**Re: SSD-6116 – Sydney International Convention Exhibition and Entertainment Precinct (SICEEP) and International Convention Centre Hotel (ICC Hotel)**

Thank you for your letter about the development proposal referenced above. We have reviewed the proposal and provide the following comments for your consideration.

SCALE @ A1	DRAWN	DESIGNED	REVIEWED	APPROVED
1 : 250	JJB	KM	-	-
PROJECT NUMBER	DRAWING NUMBER	REV		
AA004399	HO-CI-0301	05

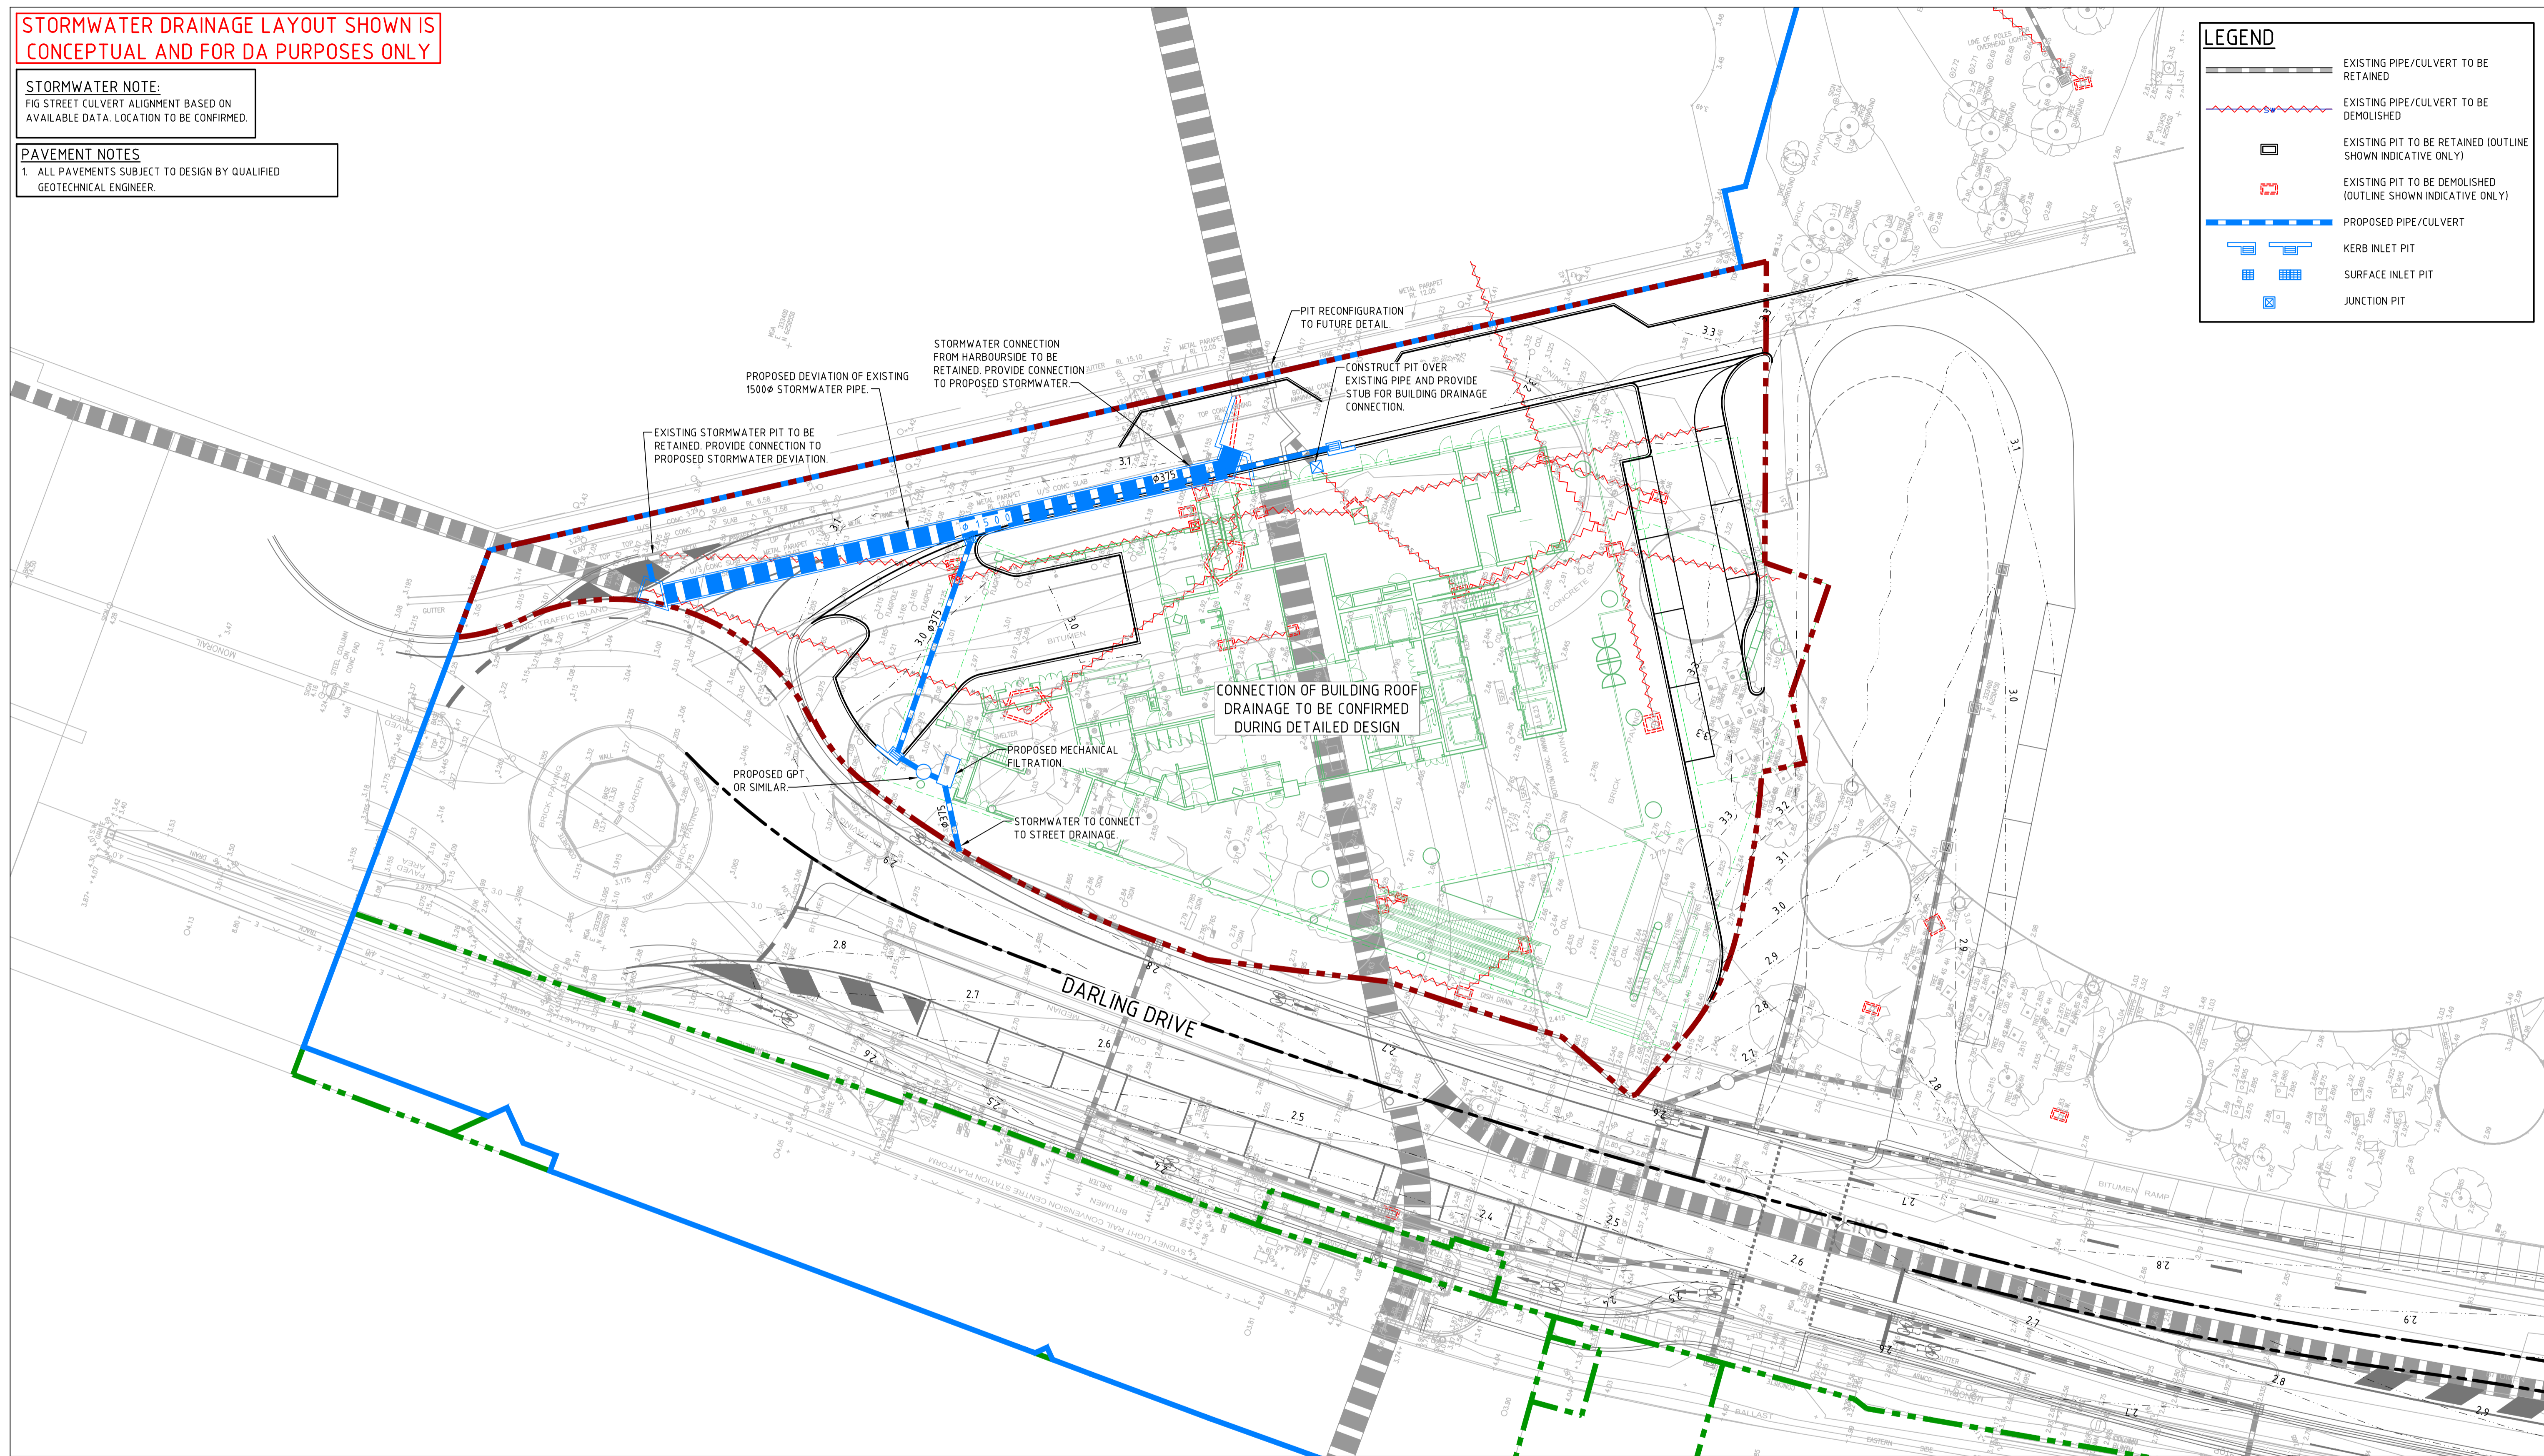
- As initially discussed with the proponents, Sydney Water is concerned with the ICC Hotel proposed over Sydney Water's 1.8H x 2.4W stormwater culvert
- As per the SICEEP Site Servicing Strategy signed by Sydney Water, the proposed Hotel does not comply or is consistent with Sydney Water's 'Building over and adjacent to stormwater assets' guidelines
- The proponents have not discussed with Sydney Water future adjustment and deviation options away from the proposed hotel
- Options to be considered must be feasible through engineering investigations, modelling, detailed concept design and must be undertaken in liaison with Sydney Water
- Any alignment route identified through this work must be reserved on the title of the land.
